Our ref: PM11/CW18/56335.1/MUNRO Your ref: EN010103 07 July 2022

Application by Net Zero Teesside Power Limited and Net Zero North Sea Storage Limited for an Order Granting Development Consent for the Net Zero Teesside Project
Planning Inspectorate Ref: EN010103
CATS North Sea Limited (Registration Identification Ref: 20029916)
Deadline 4 Response

Sheet 1 of 7 - Key Plan

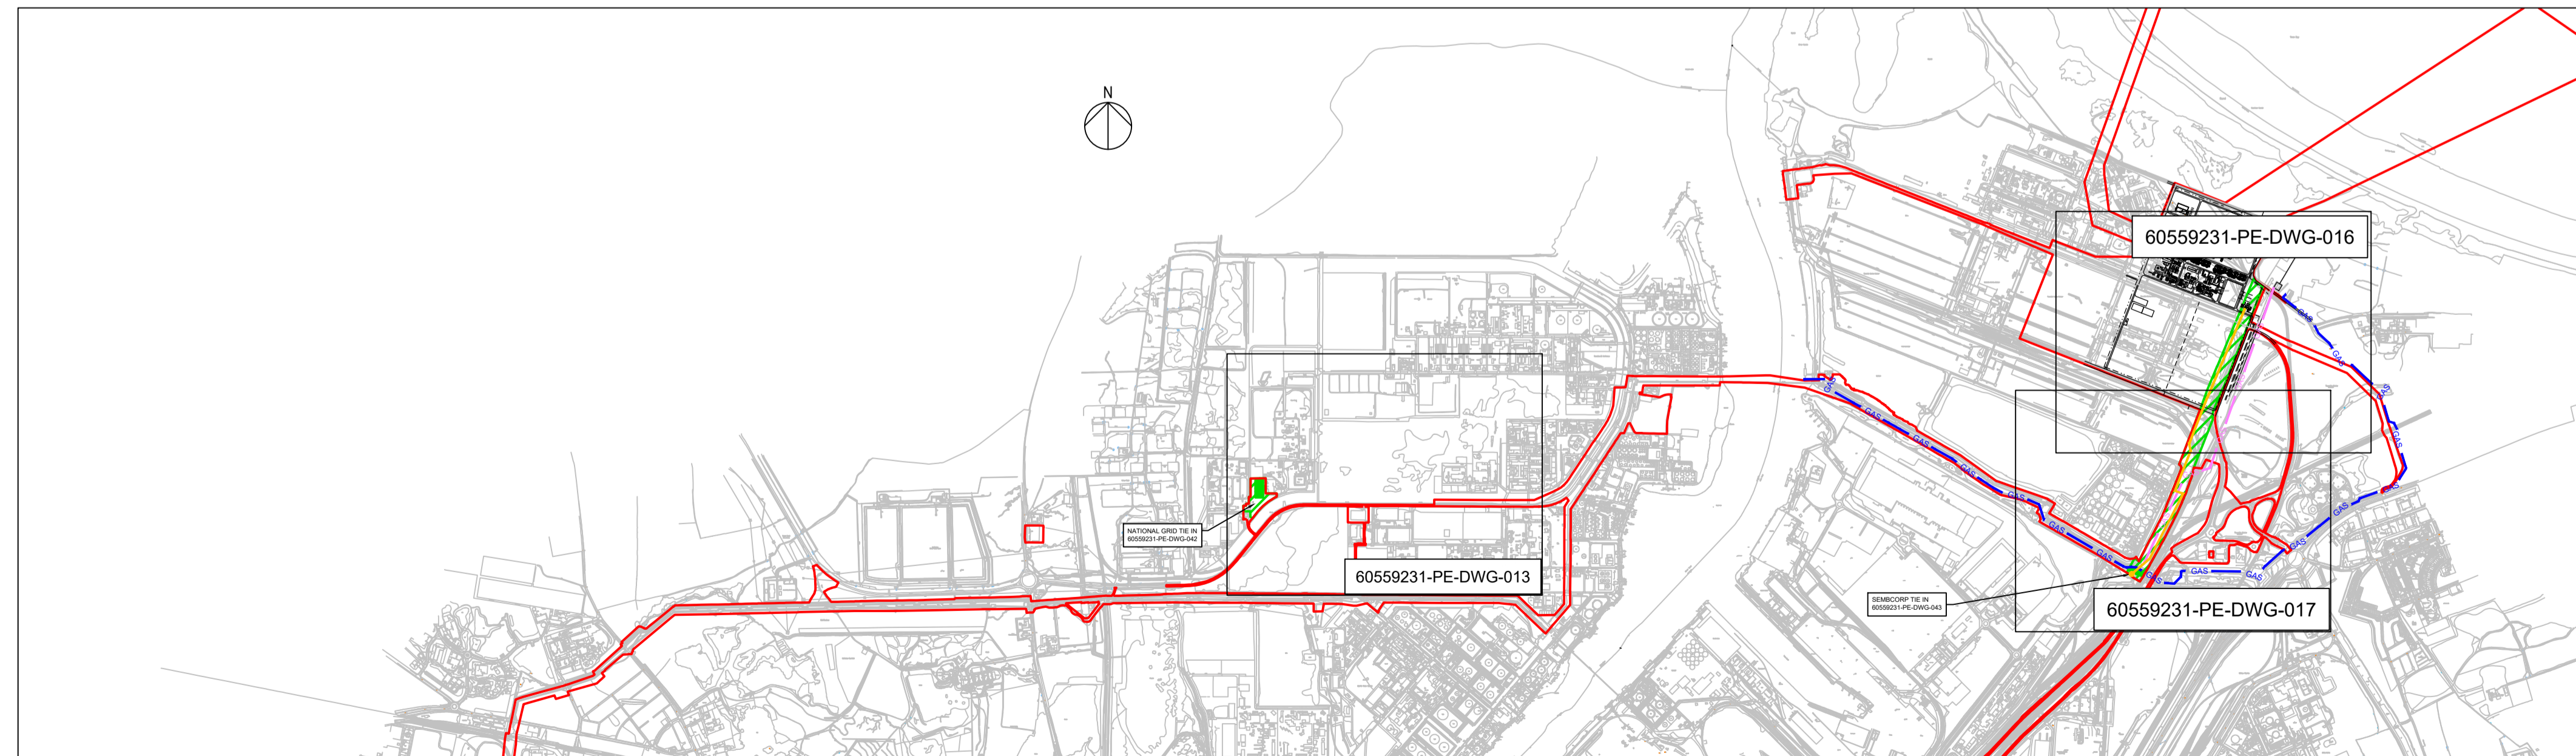
6. The Compulsory Acquisition Order Plans	The Applicants are aware of the existing CATS pipeline infrastructure and have been through the pre-application stage, and note that the CATS pipeline is for instance shown on 4.7.1 Rev 3 - Gas Connection and AGI Plans Sheet 1-7 [AS-155 to AS-161]". Considering that the Proposed Development relies on constructing a number of linear pipeline routes from North and South Tees to the PCC site, interactions with existing apparatus (including the CATS pipeline) are unavoidable.	CNSL note the Applicant's comments and refer to their Written Representation.
	It has always been the Applicants' intention to work with the operators of existing apparatus to minimise and appropriately mitigate any interactions. The Applicants established quarterly engagement meetings with the technical team operating the CATS pipeline in 2021 and more recently in 2022 these engagements have become monthly.
